SOUTH BUCKS DISTRICT COUNCIL

COMMENTS ON EXA'S FIRST WRITTEN QUESTIONS

HIGHWAYS ENGLAND'S RESPONSE

Drawing title  
SIDE ROAD PLAN & PROFILE  
REGULATION 4(2) (e)  
SHEET 13 OF 13  
OLD SLADE LANE

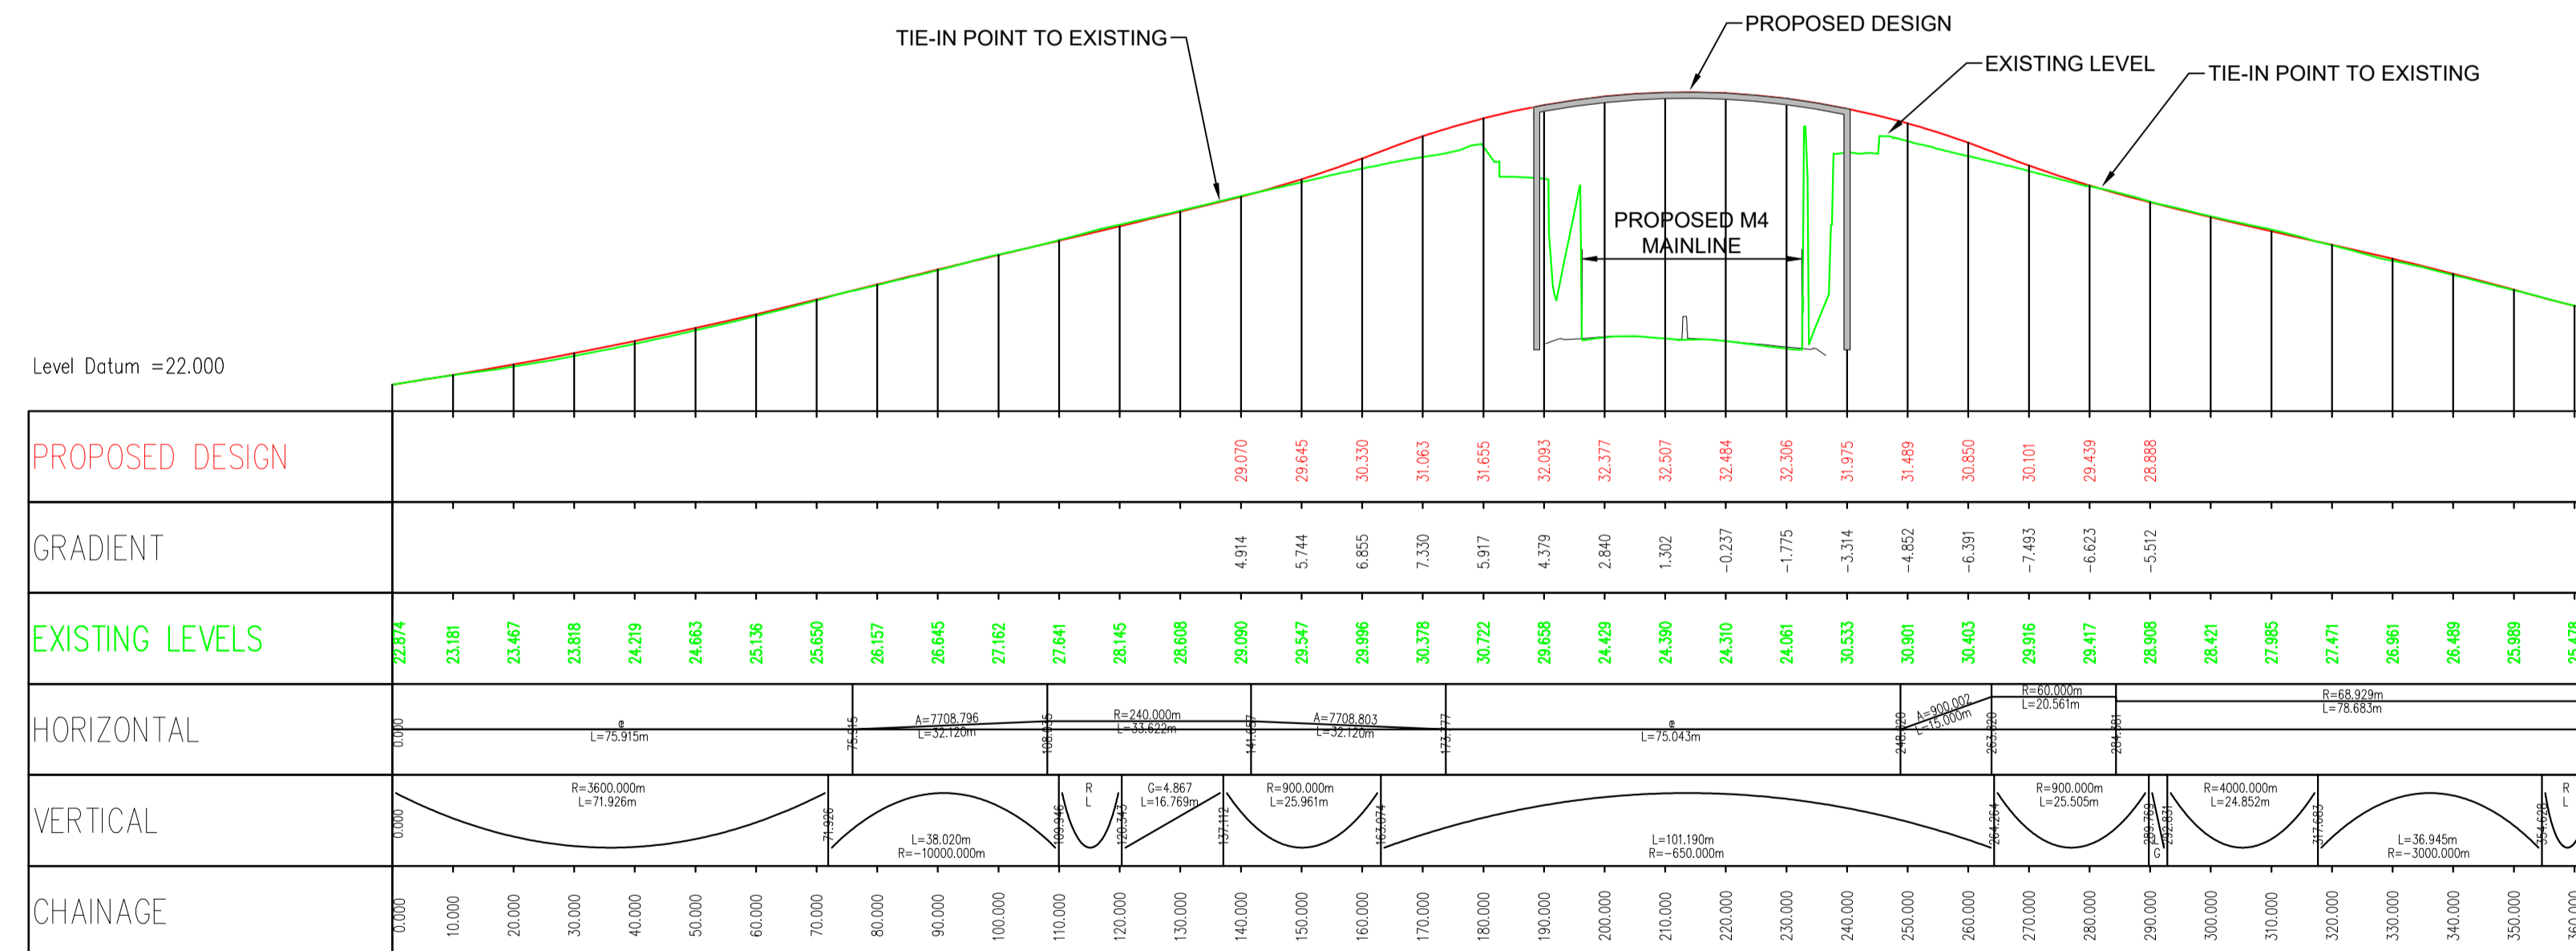
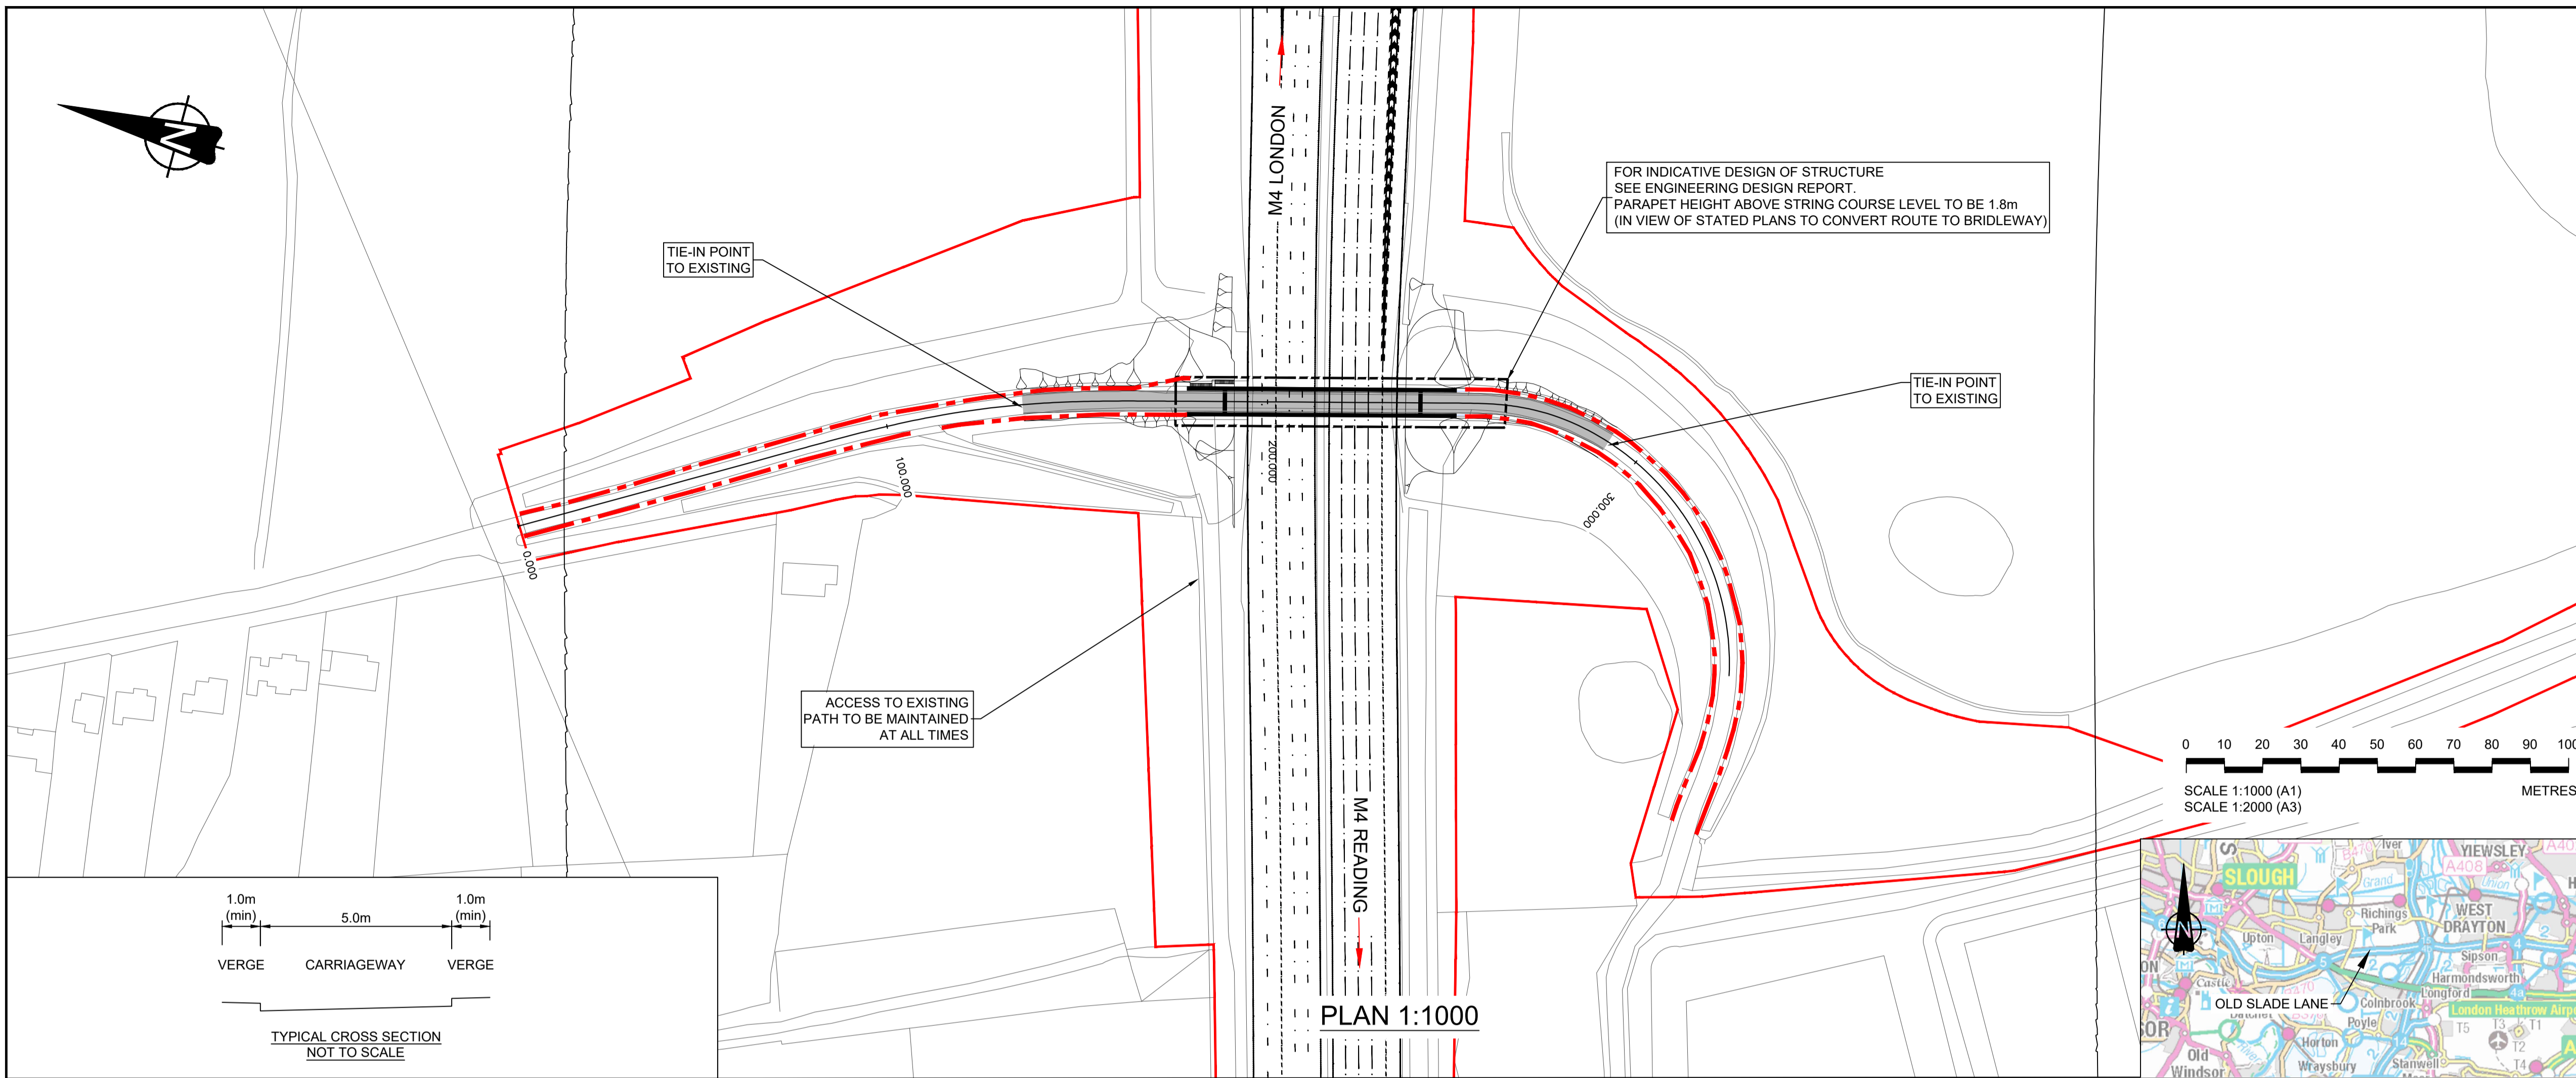
2.4	<p><i>Is the scheme compatible with regional and local strategies to increase uptake and mode share for public transport, walking and cycling?</i></p>	<p><i>No it is not compatible with local strategies designed to promote sustainable transport. There will be a negative impact on the cycle and walking network within the Colne Valley Park as a result of the proposed year long closure of the bridge at Old Slade Lane and also there will be a possible impact on the Thames Path national trail and Jubilee River rights of way during the construction of bridges in Dorney.</i></p>	<p>Sufficient mitigation has been provided for the closure of Old Slade Lane Bridge during its reconstruction</p> <p>The effect of the proposed on-line reconstruction of Old Slade Lane Bridge and the need temporarily to divert the public rights of way over it is explained in paragraph 13.7.21 of the ES. Mitigation has been provided to address temporary severance during the on-line replacement of Old Slade Lane Bridge,</p>

5.7	<i>Are the local authorities satisfied that the solution chosen for each of the overbridges or underbridges in their Council area are appropriate?</i>	<i>At present the proposal for rebuilding the bridge along Old Slade Lane is still not agreed. The Council supports the Colne Valley CIC's stance with the closure of the bridge causing a major disruption to one of the main footpath and cycleways in the park.</i>	The Highways England Team have been consulting with South Bucks District Council since March 2013 on the proposals to replace the overbridges over the M4 as part of the smart motorway scheme. As a result of that engagement with the Council we were aware of the

<i>Question No</i>	<i>Question</i>	<i>SBDC Response</i>	Highways England Response
			<p>comprising a temporary diversion route to the south via Colnbrook Bypass, Sutton Lane, and North Park (see Figure 2.1 Sheet 13 of 16) (Application Document Reference 6-2).</p> <p>The significance of the residual effect of the bridge replacement on users of Old Slade Lane Bridge for pedestrians, cyclists and equestrians, where there is no suitable alternative route for the duration of the construction period (some 12 months) is detailed in paragraphs 13.7.21 and 14.11.13 of the ES. The assessment results in a moderate to large adverse effect in terms of severance and a severe effect in terms of effects on all travellers due to the length of the diversion. It should be noted however, that these effects will be of a temporary duration during the construction period and will impact on a relatively small number of individuals. Two 12 hour counts of users of the bridge were undertaken on 3 and 6 June 2015, which found a relatively low level of usage. On Wednesday 3 June 2015, a total of 58 people used the bridge (45 adults, 6 children and 7 cyclists) and on Saturday 6 June 2015 44 people were observed</p>

<i>Question No</i>	<i>Question</i>	<i>SBDC Response</i>	Highways England Response
			<p>importance of the Colne Valley route and the intent to form a bridleway across the Old Slade Lane bridge in due course. It is for this reason that the proposals include for a shared vehicle/non-motorised use provision across the bridge with the use of 1.8m high parapets to accommodate equestrian usage.</p> <p>The bridge replacement is based on construction being on-line to avoid the need for additional land given that current movements across the bridge are understood to be relatively low (as per the answer to 2.4 above in this document). Such an on-line replacement solution relies on using a diversion route during construction..</p>

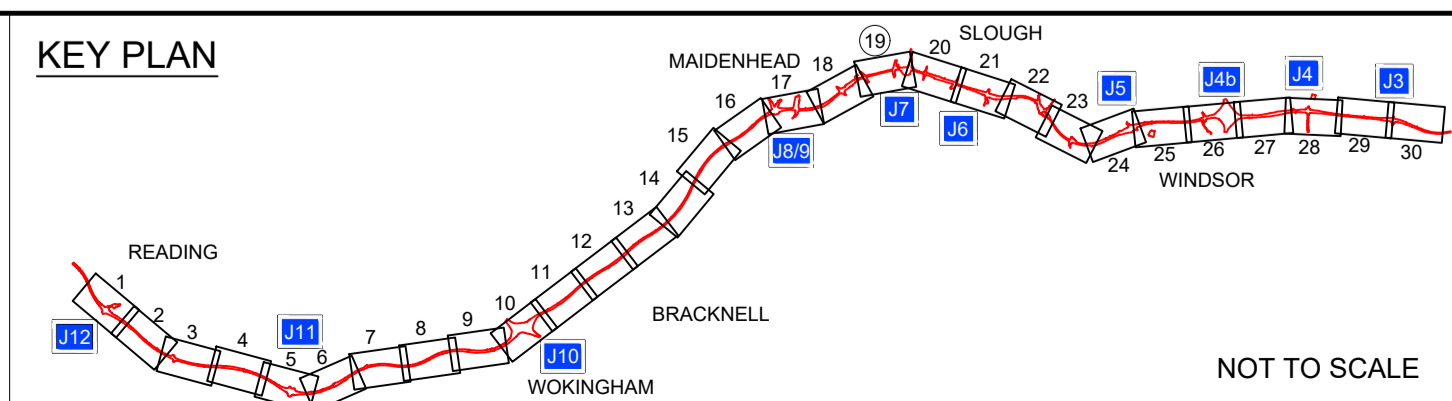
2.2	<i>Do the local authorities agree the applicant's assessment of the project against the relevant policies of each Council? If not, please identify any areas of conflict and explain the reasons why the project would be in conflict.</i>	<p><i>The key policy areas of concern for SBDC are:</i></p> <ul style="list-style-type: none"> - <i>L4 River Thames Setting (how the Thames Bray Bridge development will impact the River Thames setting)</i> 	Policy L4 of the Adopted Local Plan 1999 (Saved Policies 2007) provides the statutory policy guidance against which to consider the effects of the Scheme on the setting of the River Thames. This has been done in Chapter 8 of the ES (Application Document Reference 6-1) through considering the effects of the Scheme on the landscape and visual amenity at this location. The massing, cross section and elevation details of the proposed replacement Thames Bray

<i>Question No</i>	<i>Question</i>	<i>SBDC Response</i>	Highways England Response
			Bridge as indicated in the EDR and the associated vegetation clearance and mitigation, in the EDR, Annex A2, Vegetation Clearance, Sheet 19, and
		<p>- <i>L10 Felling trees protected by a TPO (there is currently no details of how many protected trees will be lost and mitigation guidance should any be knocked down)</i></p>	<p>Annex A1, Environmental Masterplan, Sheet 19 (Application Document Reference 7-4) have been taken into account in the assessment of landscape and visual effects provided in Chapter 8 of the ES (Application Document Reference 6-1). Whilst vegetation clearance will be required, replacement planting is proposed. As set out in Table 8.2 of the ES, the landscape and visual effects (relating to the landscape character of the locality and visual amenity of those with views to Thames Bray Bridge) during construction are assessed to be moderate to large adverse, reducing to slight adverse by Design Year (2037 - 15 years after construction), due to establishment of planting.</p> <p>The outline Construction Environmental Management Plan (“CEMP”) (Appendix 4.2A of the ES) (Application Document Reference 6-3), requires the contractor to employ the services of an arboriculturalist to carry out a tree survey</p>
